Application No: FG/69/22/HH
Site Address: Tanglewood Rifside Gardens Ferring BN12 6QH
Description of works: Erection of single storey front and side/rear extensions and installation of rear roof terrace and cladding to dwelling.

Thank you for your internet representation made on 20th May 2022 which has been recorded as an objection with the comments as follows:

Proposed Side and Front Extensions
Planning Permission

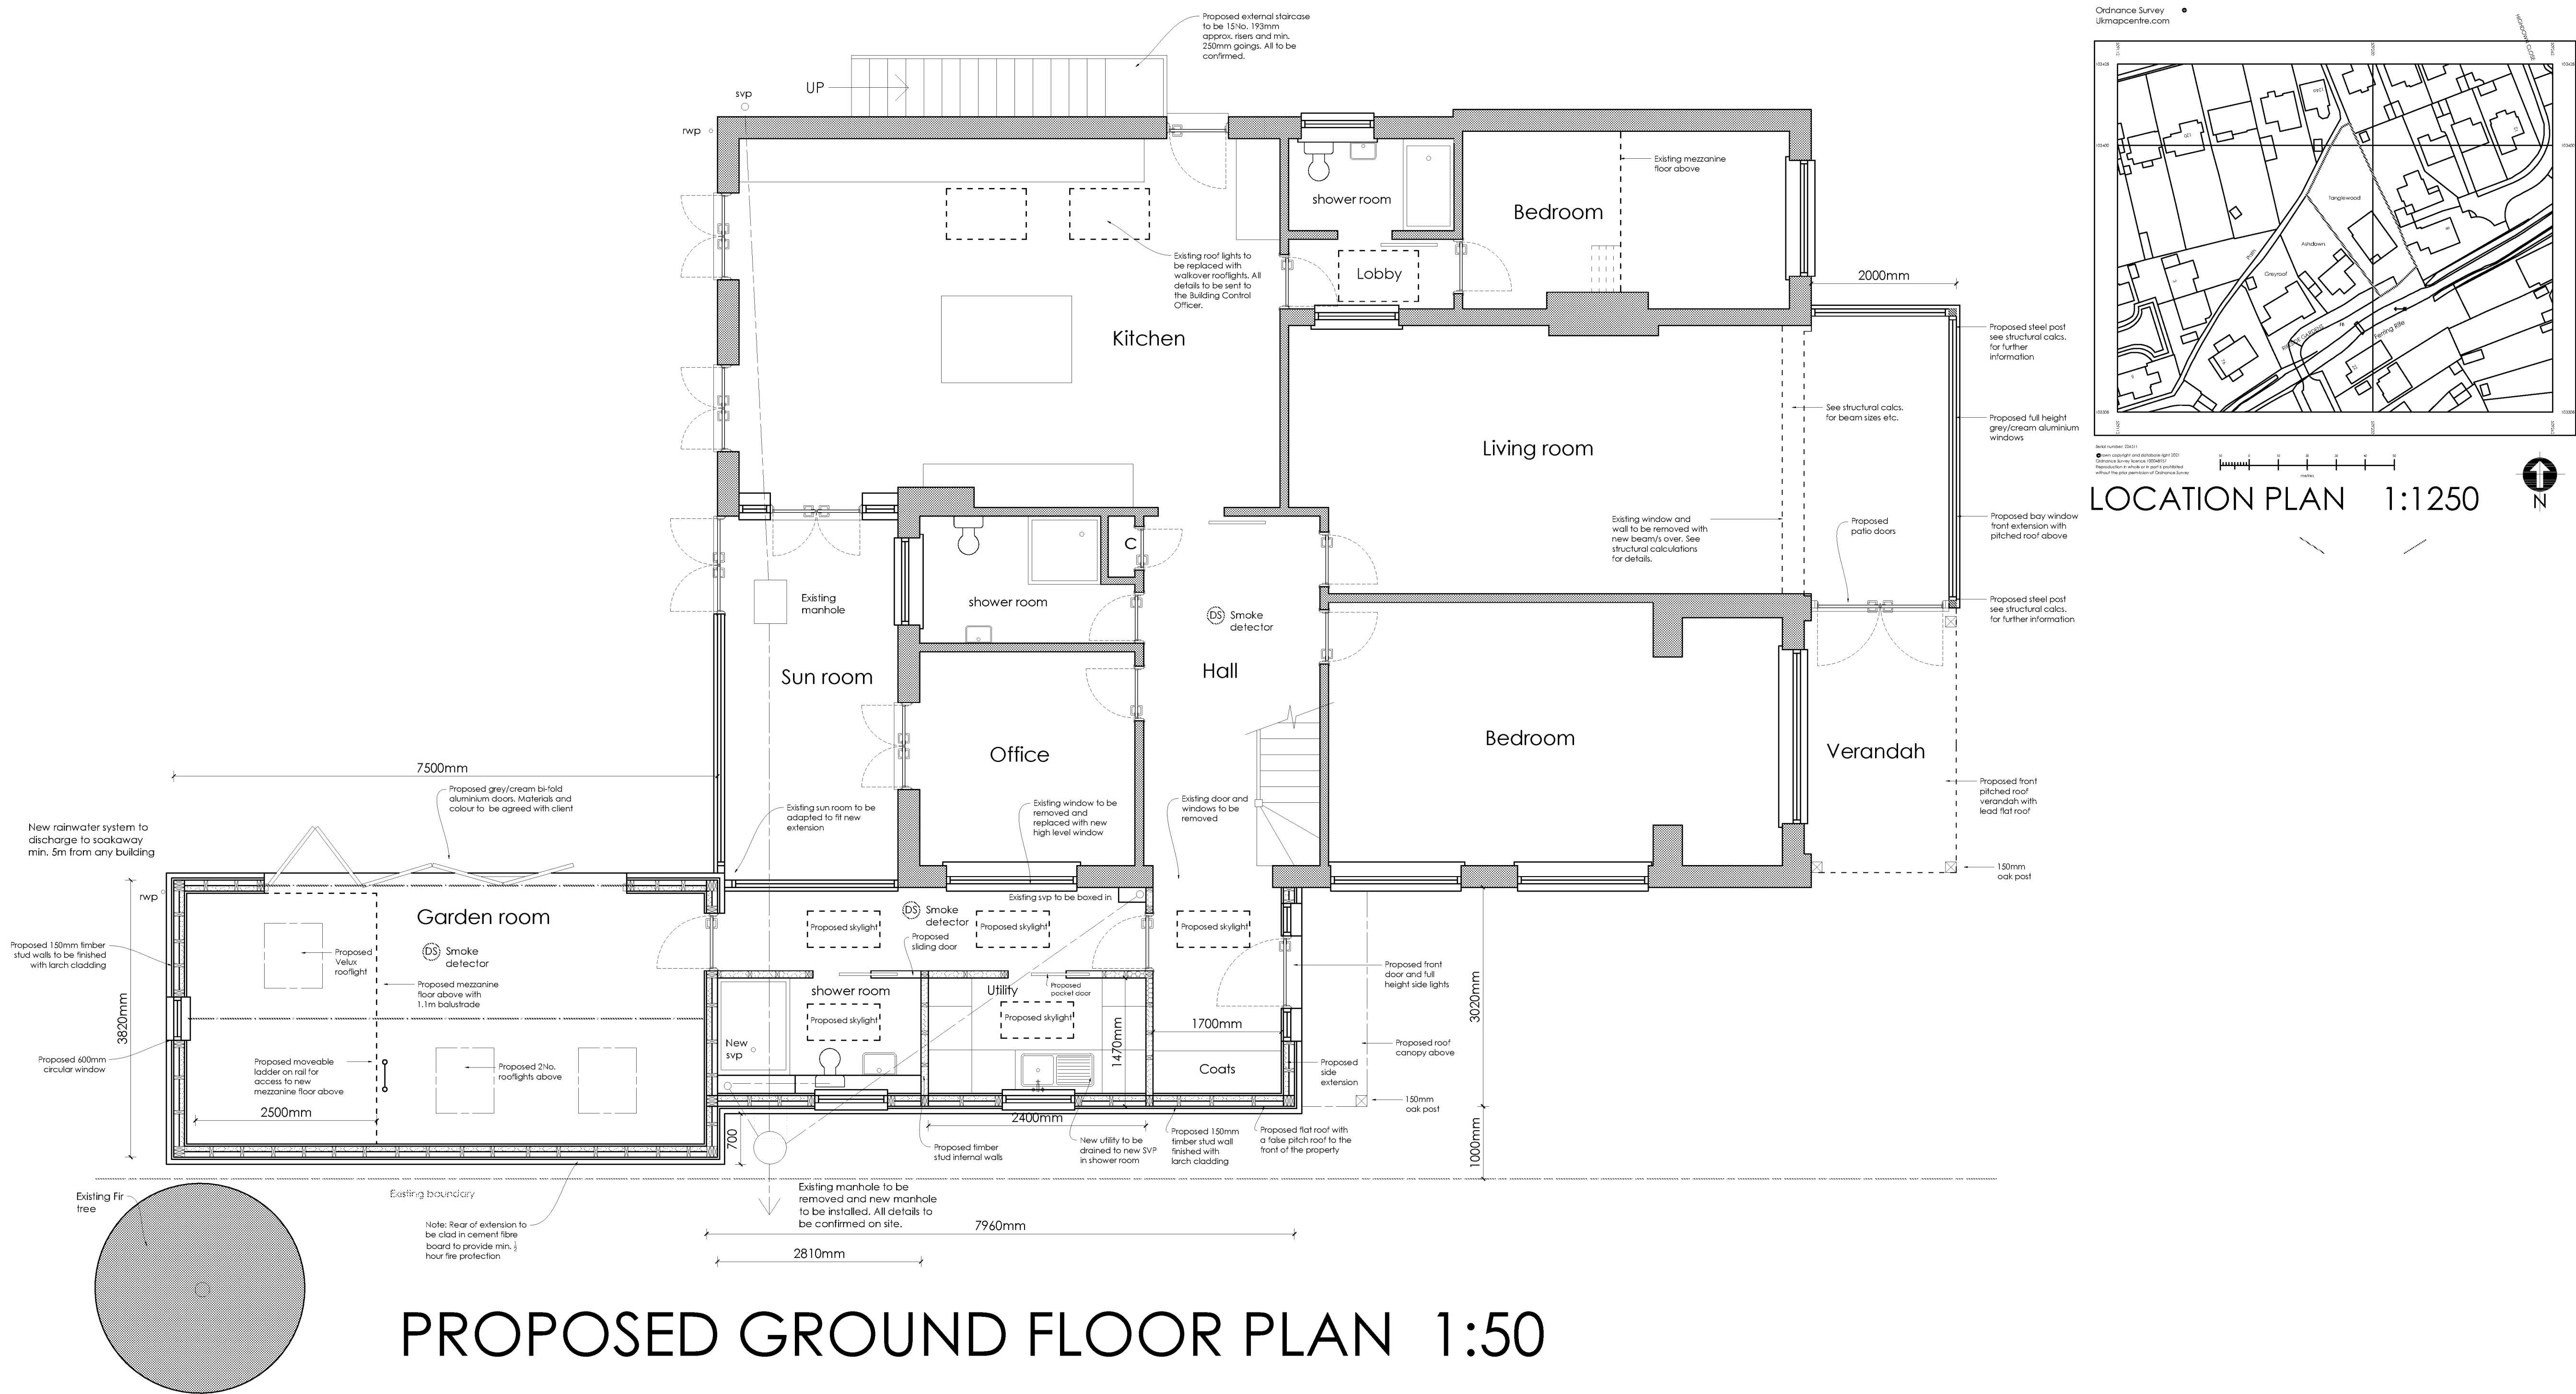
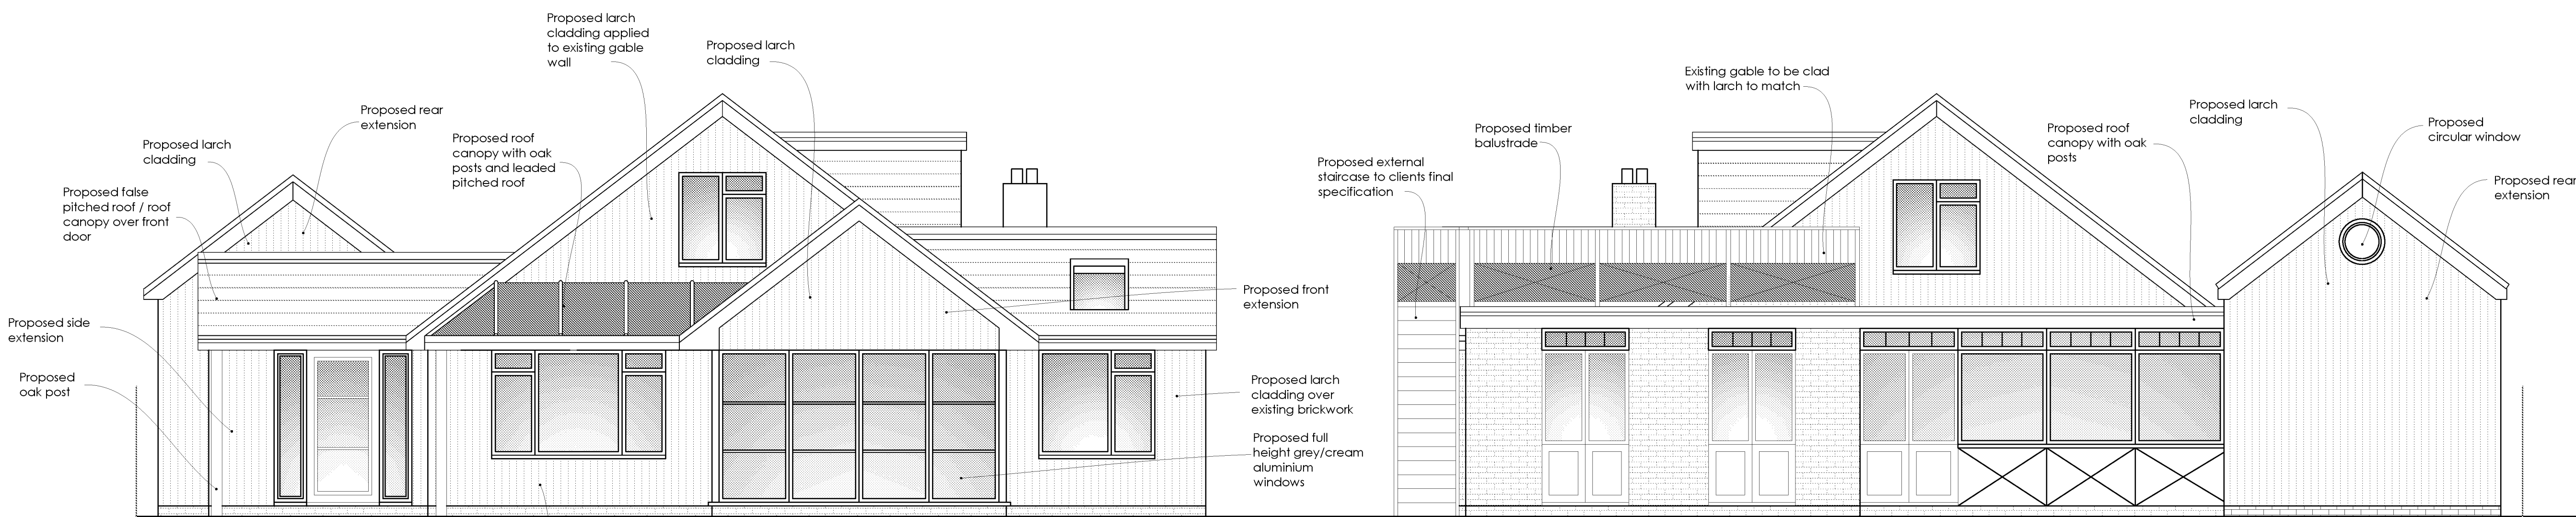
In relation to the front extension this should not exceed my property footprint and the Tanglewood fence line should be extended with adequate permanent screening to prevent any overlooking and loss of privacy into my front bedrooms from the new proposed full height windows on the front bedroom extension.

All new windows installed along my boundary should be permanently obscure and non-opening to avoid any further overlooking and loss of privacy.

PROPOSED ROOF PLAN 1:50

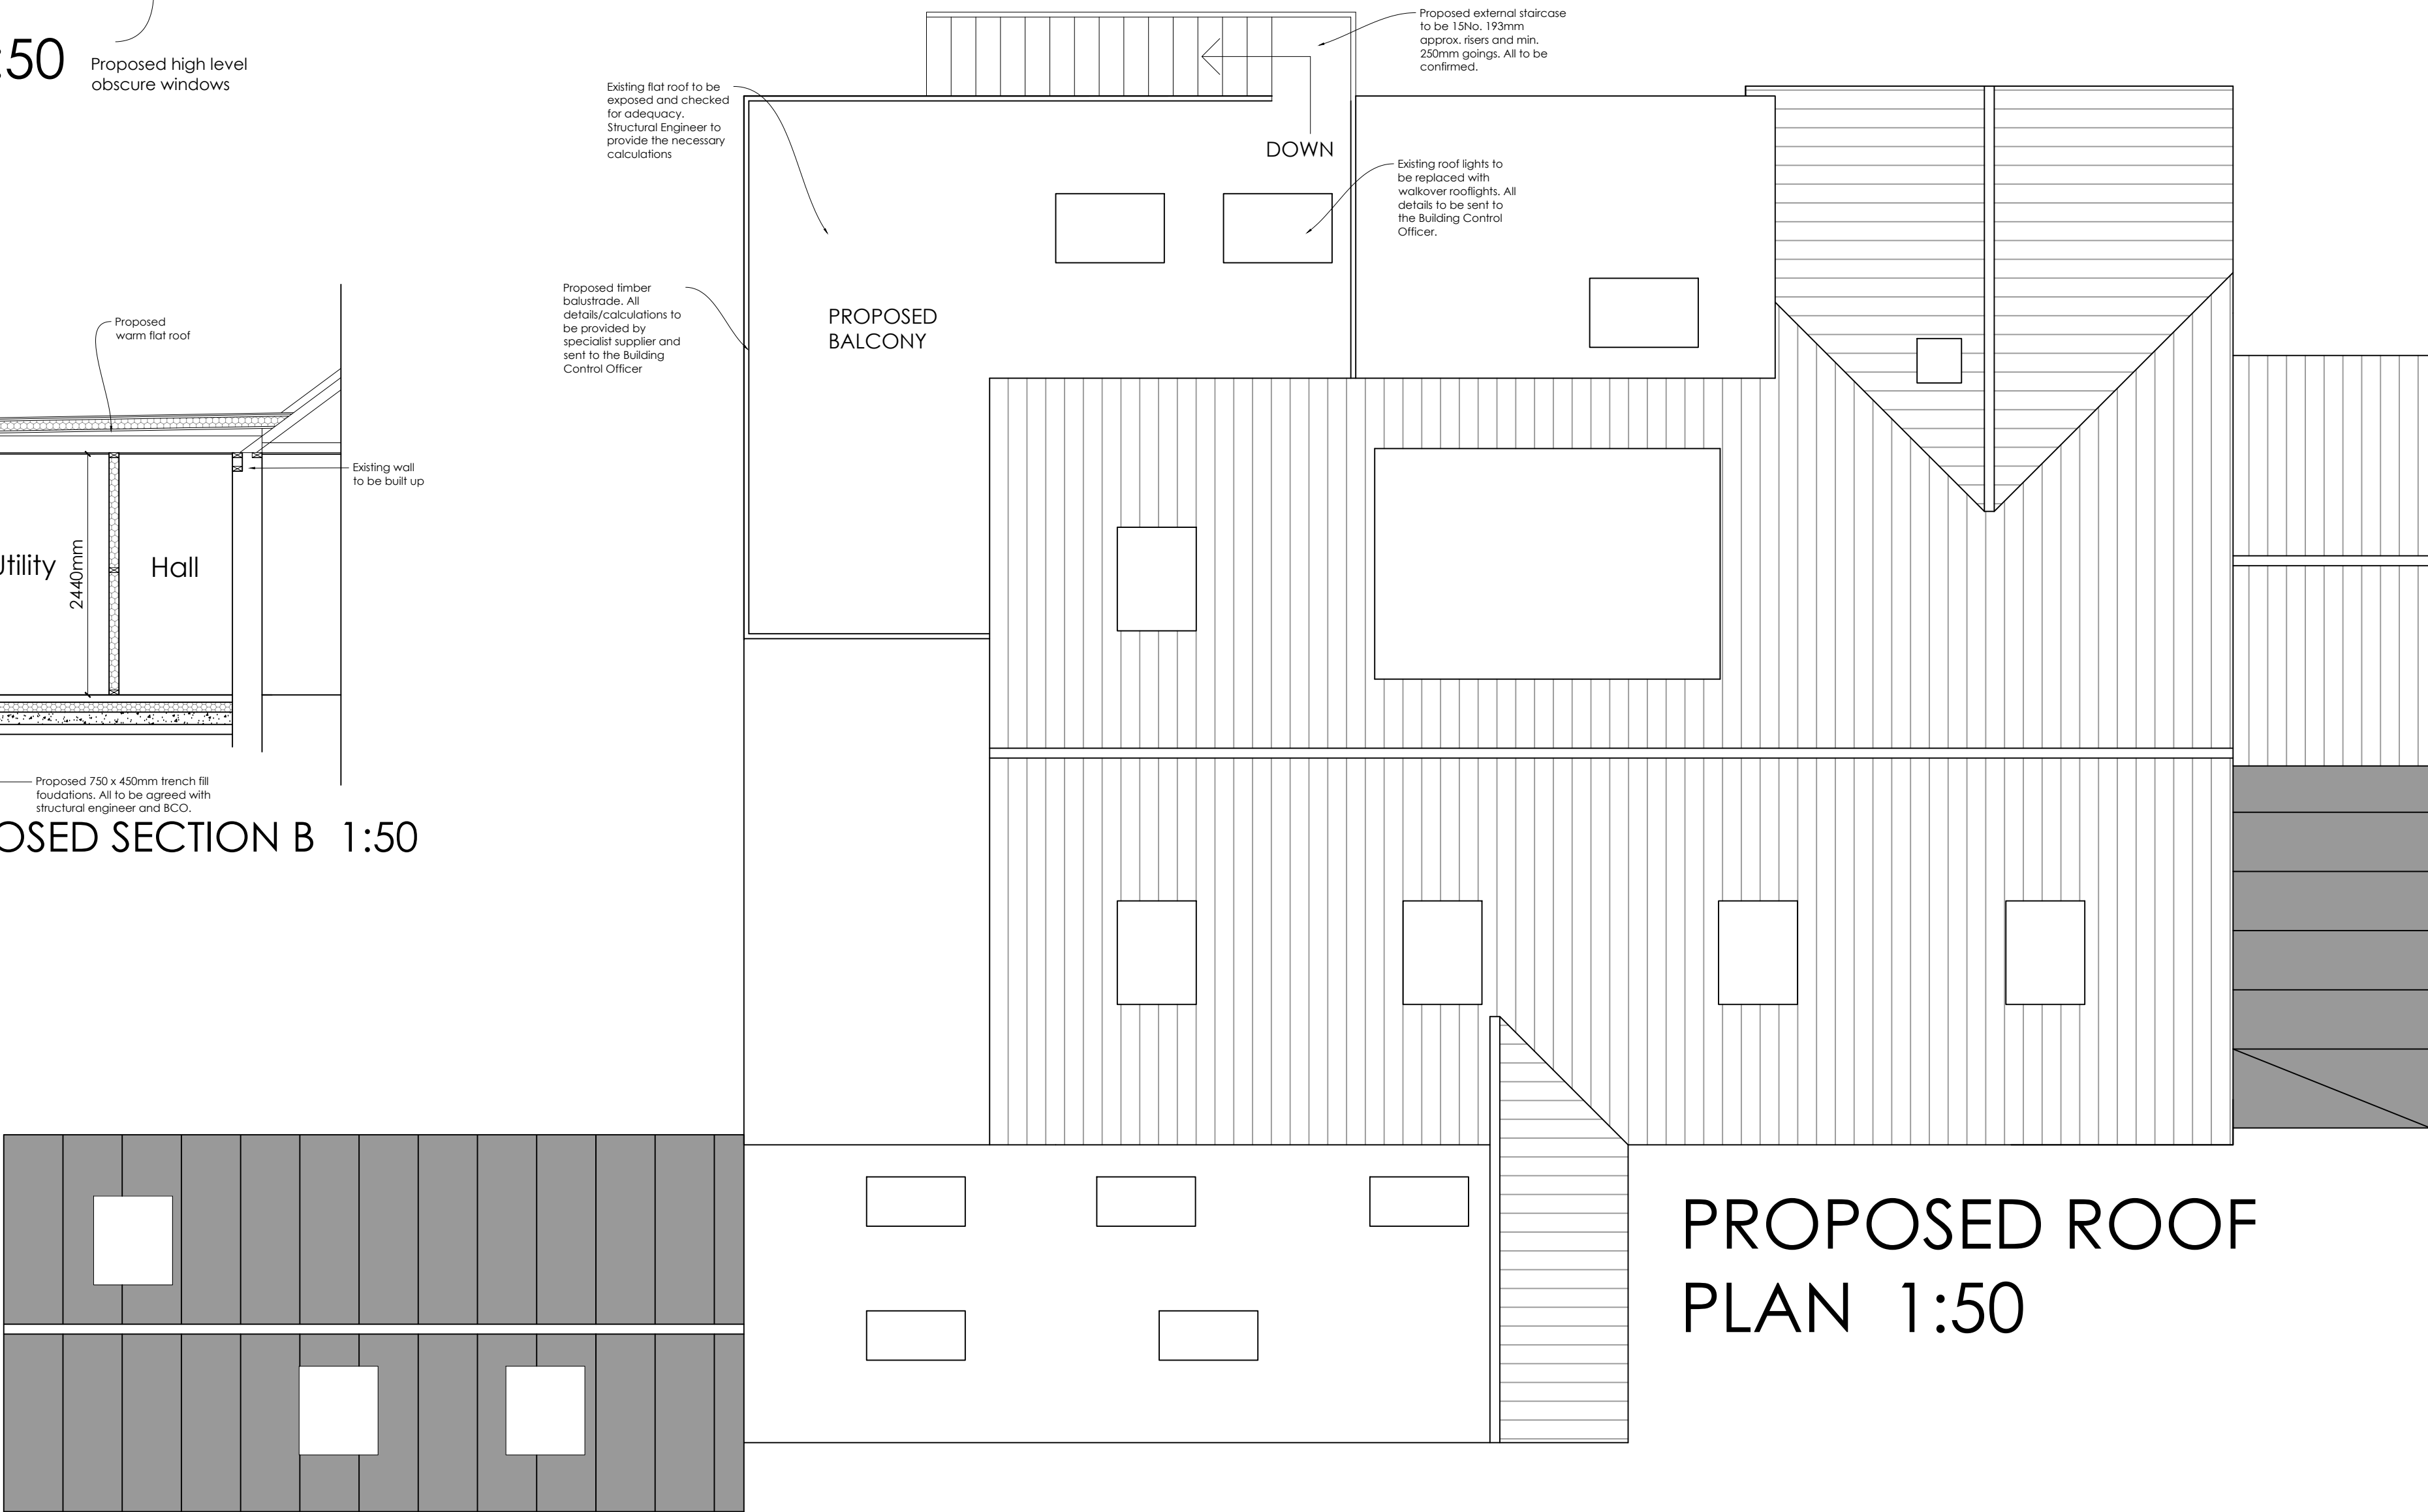
I would like to object to any balcony along my boundary as this would overlook the rooms in my property and would cause a significant overlooking and loss of privacy to my property. The scale and type of the proposed development is excessive and not in keeping with the area.
